CITY OF ALBUQUERQUE

PLANNING DEPARTMENT – Development Review Services

RE: Valle Vista ES Bus Lane- 1700 Mae Ave. SW
Grading and Drainage Plan
Engineer's Stamp Date 9-22-2014 (File: K12D027)

GRADING PLAN BUS LANE IMPROVEMENTS VALLE VISTA ELEMENTARY SCHOOL

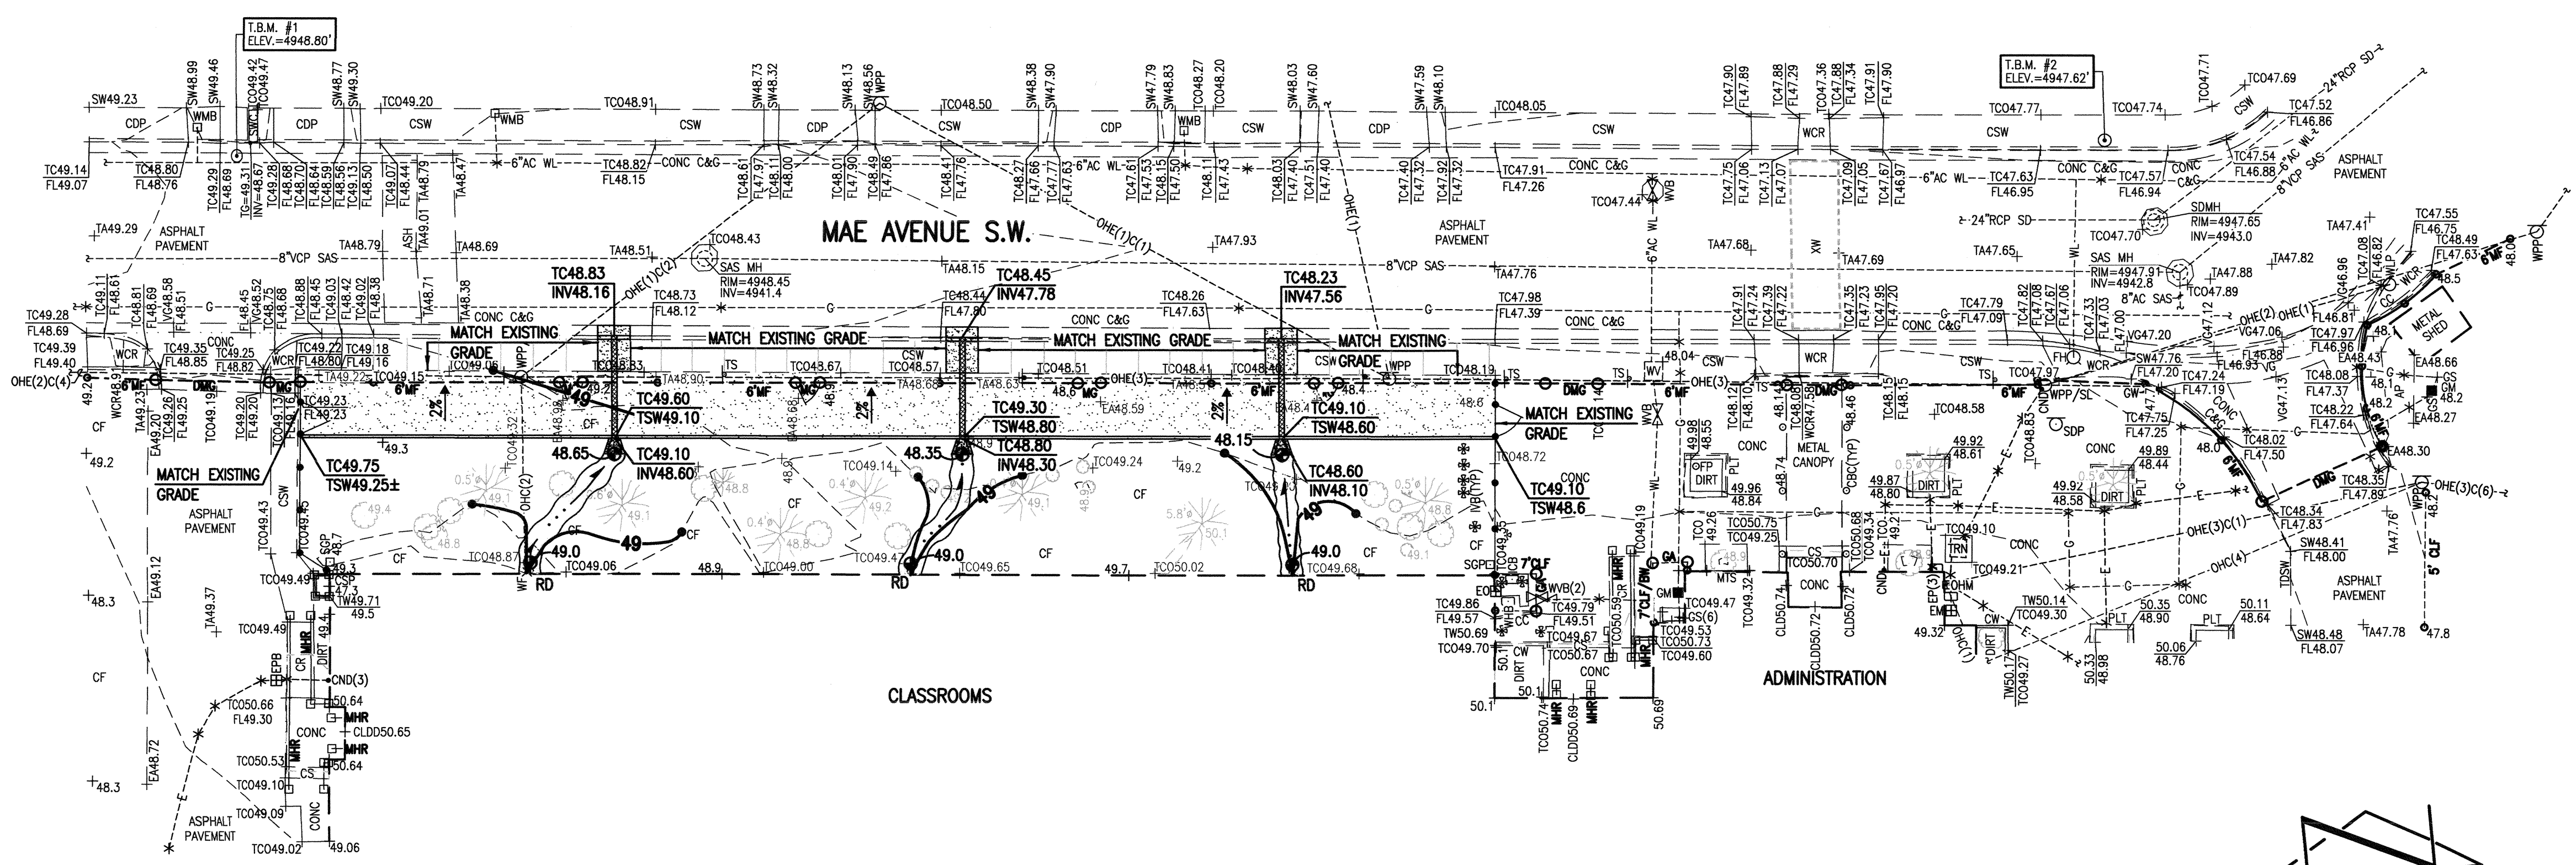
- 1) In the Project Description, state that project lies within SFHA AH and state the BFE.
- 2) Obtain a Floodplain Permit for construction within the Flood Plain.
- 3) Note that the grate on the sidewalk culverts must be tack welded to the embedded anchors.
- 4) The Standard SO-19 Construction Notes are attached. In particular, the title needs to be changed and note 6 needs to be added. The signature block should remain.
- 5) The SO-19 approval is for the Sidewalk culverts only. The curb painting is not a part of this approval.
